GALLOWAY
RESPONSE

SUBJECT: Engineering Review Comment
Mountain View Electric Association Inc. (MVEA)

Project Name: Falcon Ranchettes Filing No. 2

Project Number: VR239

MERIDIAN PARK DRIVE - PUBLIC 60' R.O.W.  
25 MPH DESIGN SPEED (LOCAL)  
SCALE: 1"=30'

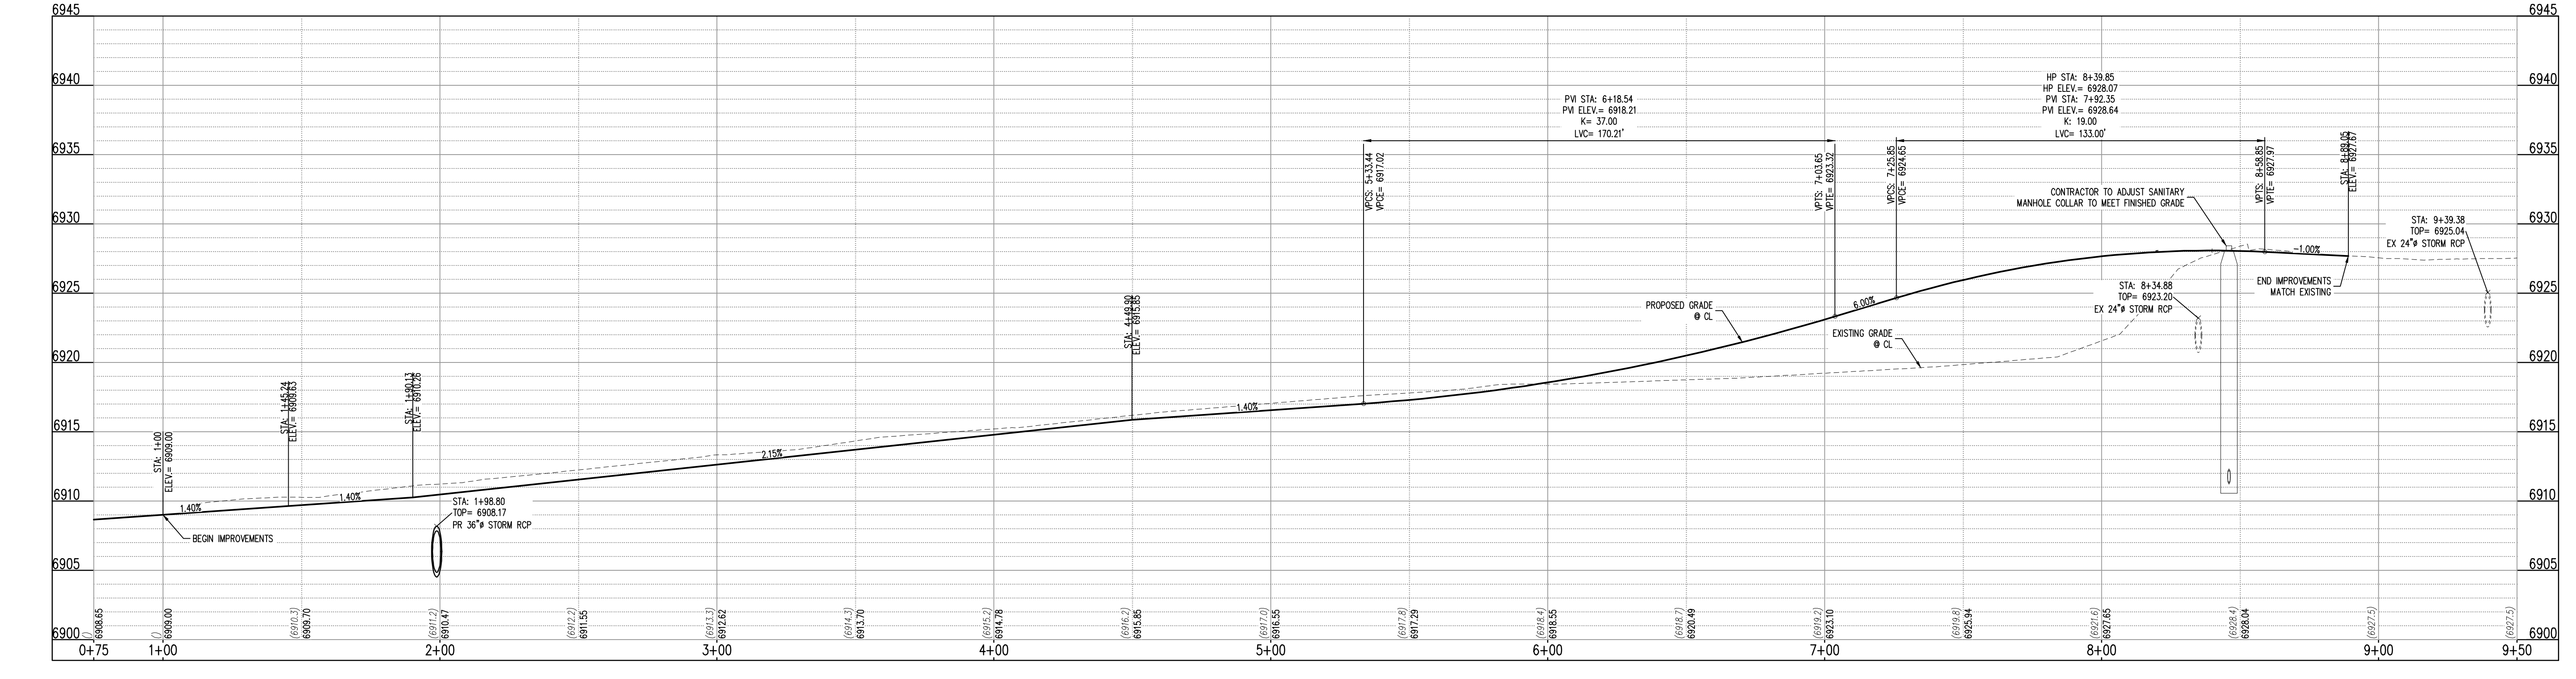
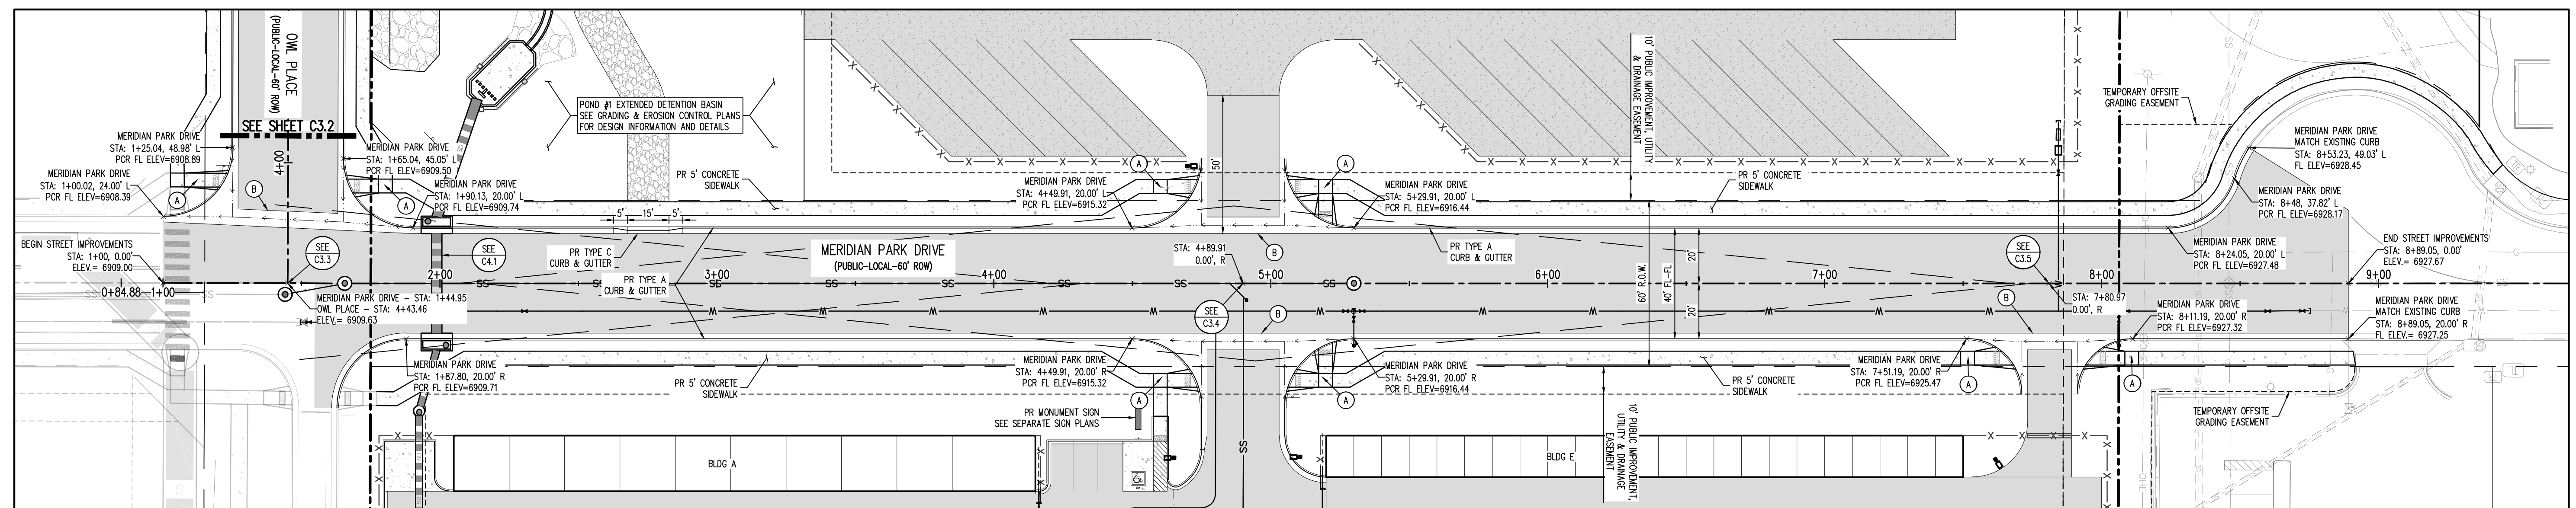
MVEA has facilities within the proposed Meridian Park Dr. and requests a twenty (20) foot utility easement on the East and West sides of the proposed road. MVEA also requests the platting of MVEA's existing facilities with easements on the plat. Additional easements may apply.

UNADDRESSED.
WILL COORDINATE
NEXT SUBMITTAL
